Application number: 2022/90404	
What is the application for?:	Erection of three storey rear extension
Address of the site or building:	8, Ashbourne View, Cleckheaton, BD19 5JE
Postcode:	BD19 5JE

Proposed elevations

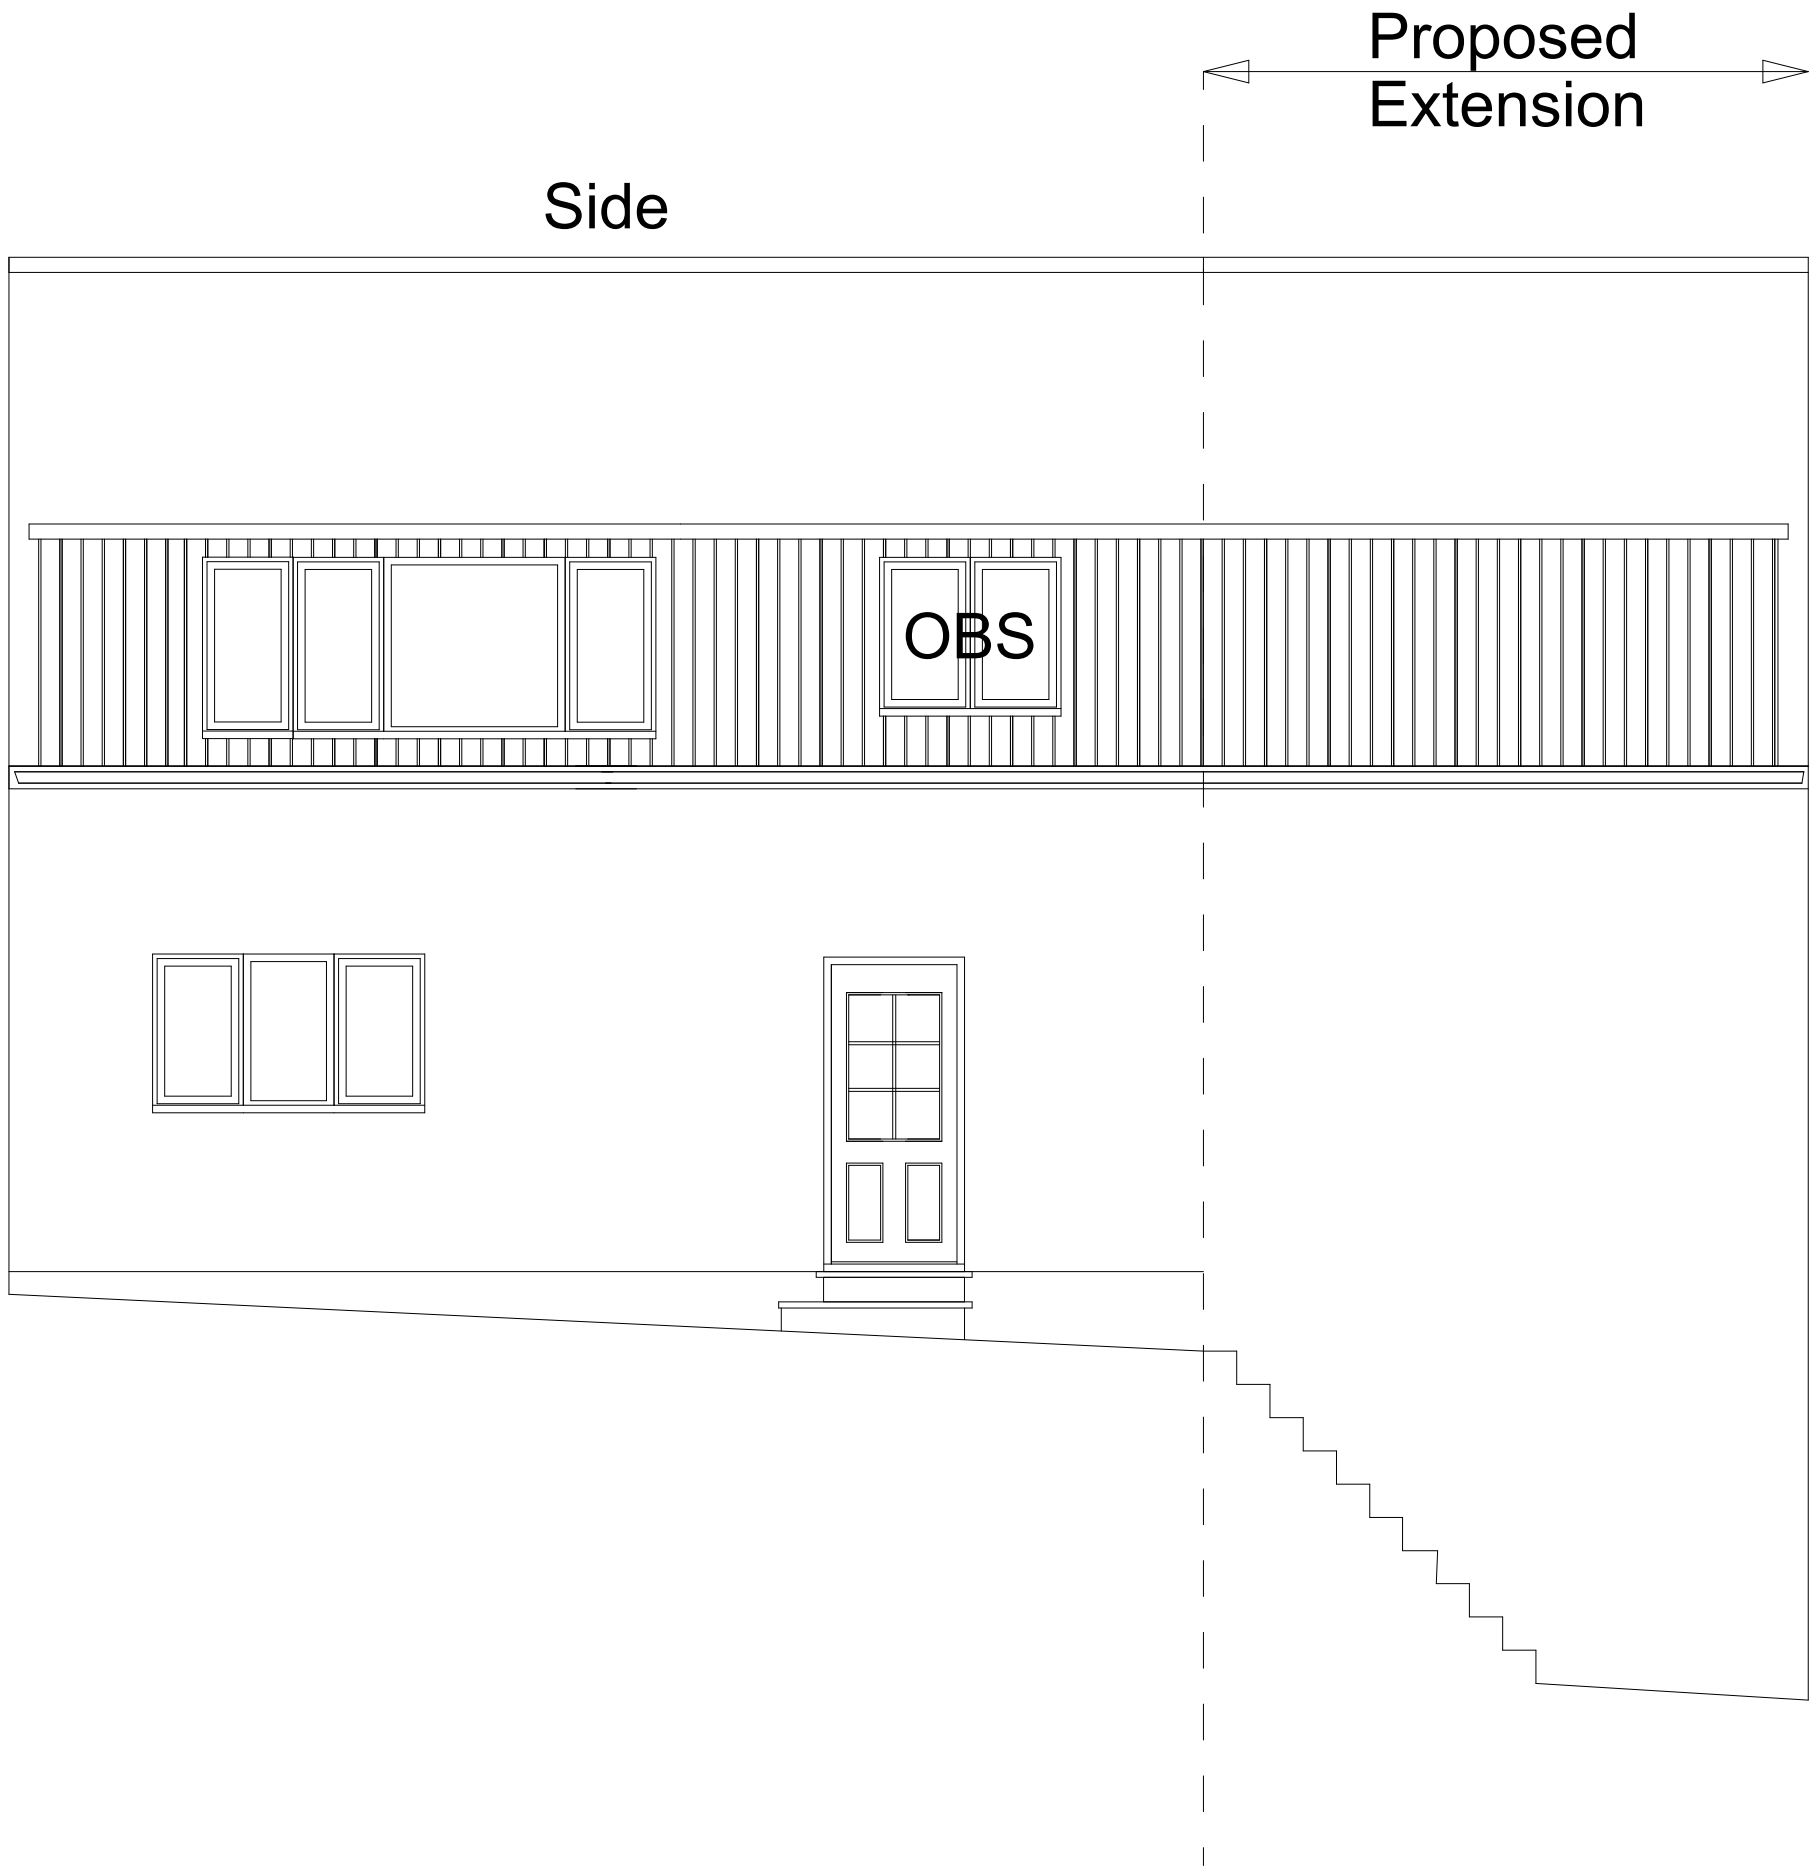
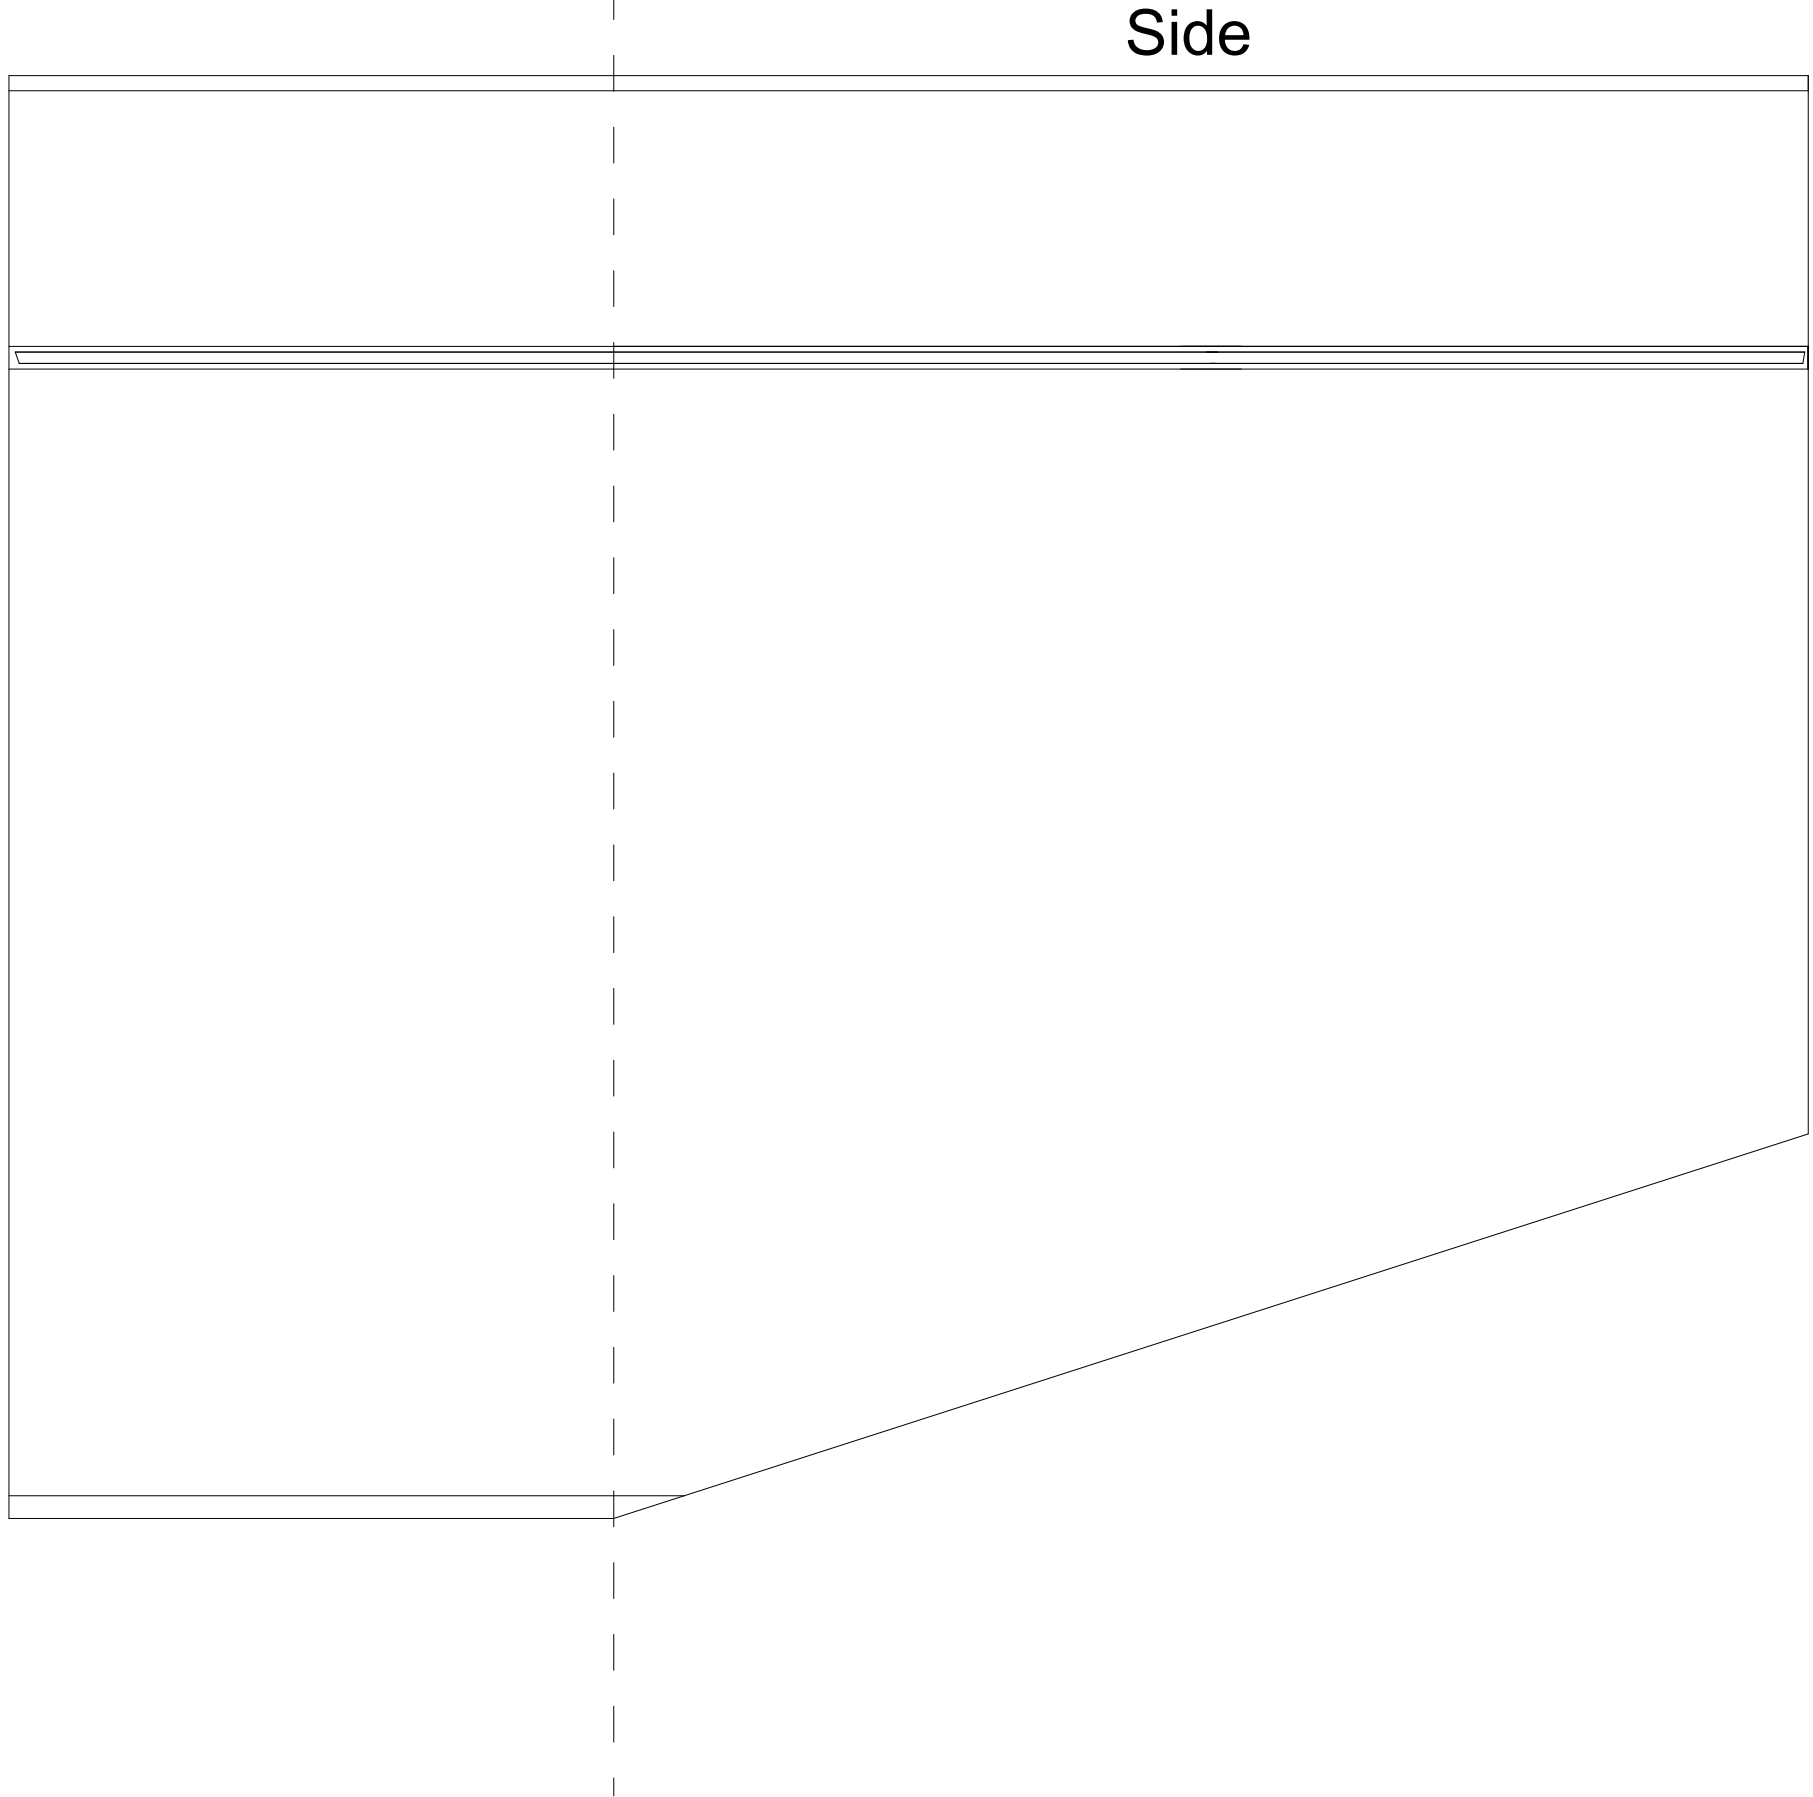
Type of comment: A general comment	
Do you wish your comments to be published on the website anonymously?	Yes
The extension seems excessive in size. We are concerned about the effect the extension will have on our daylight and sunlight. Being 3 storeys high and 4 metres out we feel it will deplete the amount of light we recieve putting us in more shadow for a longer period of time.
